# CITY OF PORTLAND

# BUILDING PERMIT

Job ID: 2012-06-4175-ALTR

has permission to build an attached garage with a second floor (Single Family Residence).

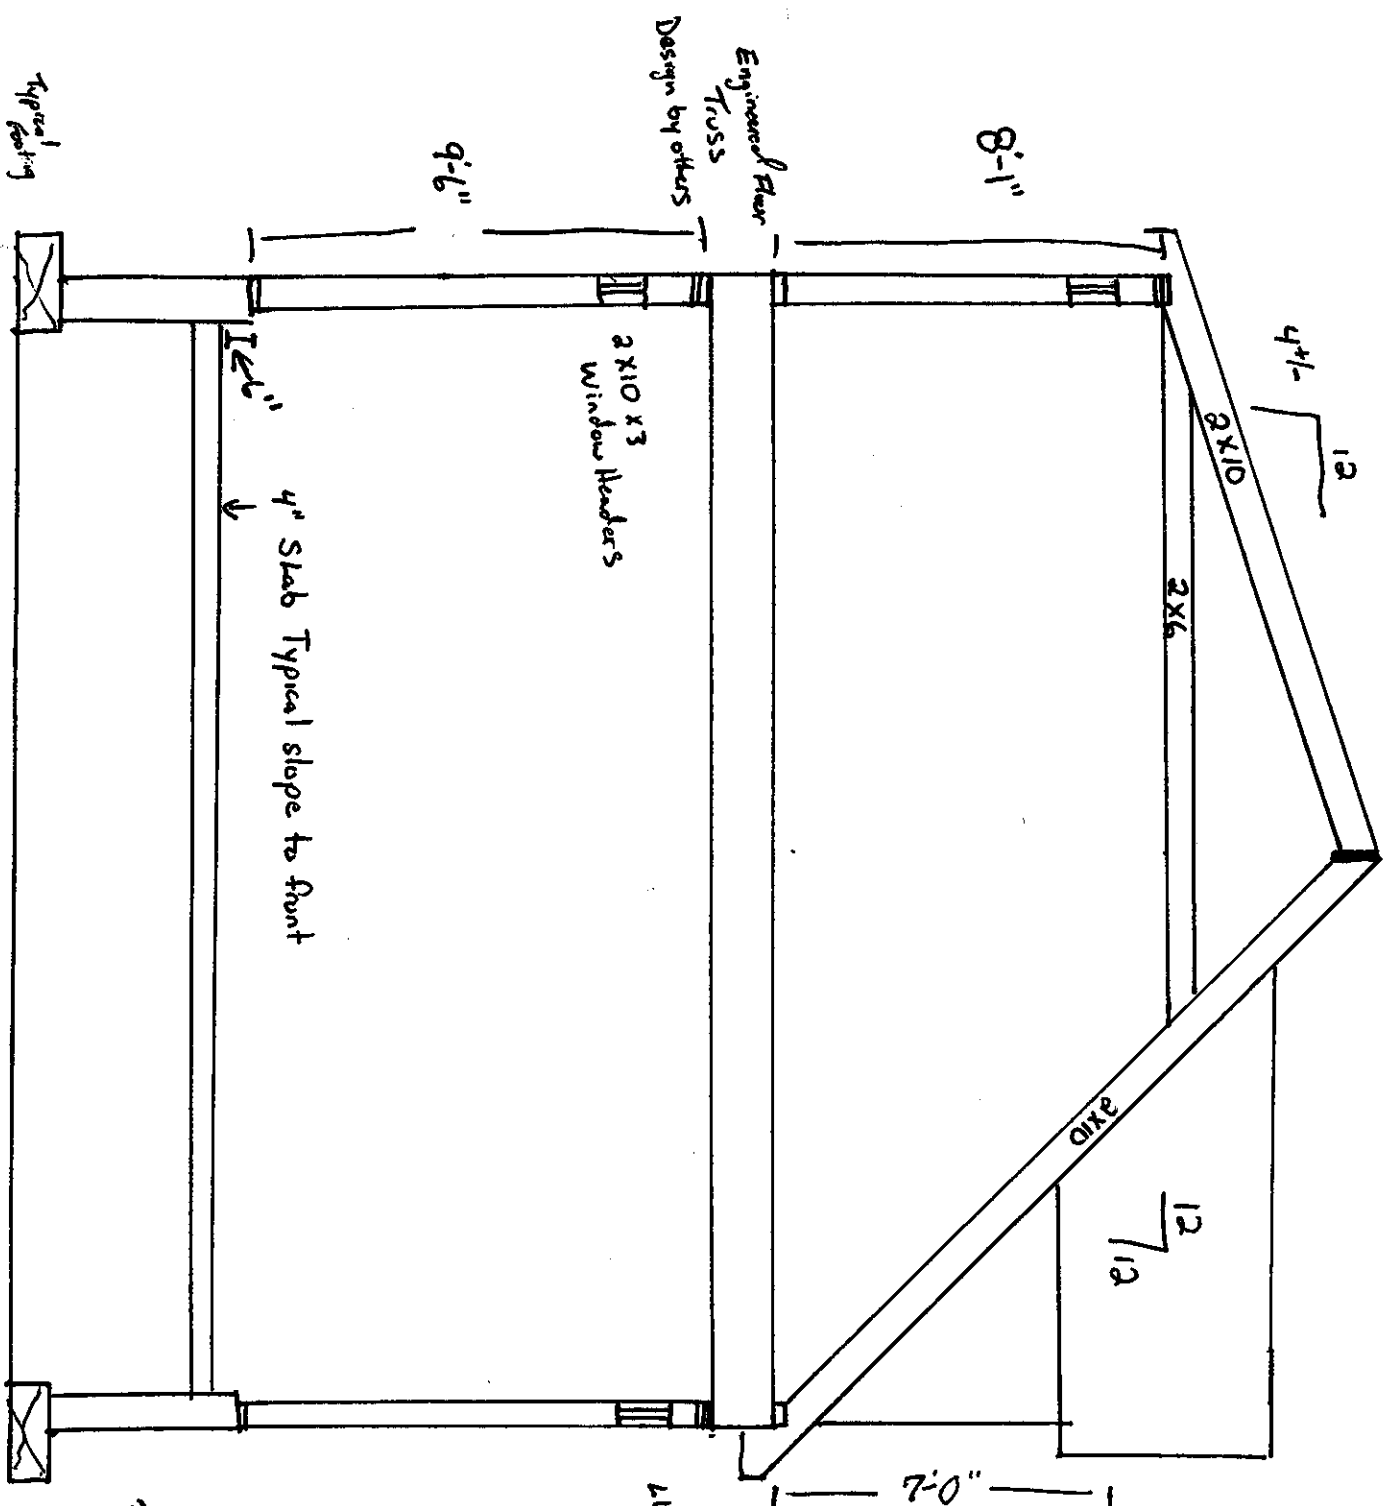
2. Frost protection must be installed per the enclosed detail as discussed w/owner/contractor (at least 4' from grade).
3. Ventilation of this space is required per ASRAE 62.2 , 2007 edition; Contractor agreed that the "building envelope" insulation will comply with the IECC, 2009 (Maine State Energy Codes).

8. Submit Engineered Specifications for Floor Trusses.
9. Anchor Bolts/Straps, spacing per Section R403.1.6 of MUBEC.
10. **R802.4 Allowable ceiling joist spans shall be in accordance with Tables R802.4(1) and R802.4(2).**
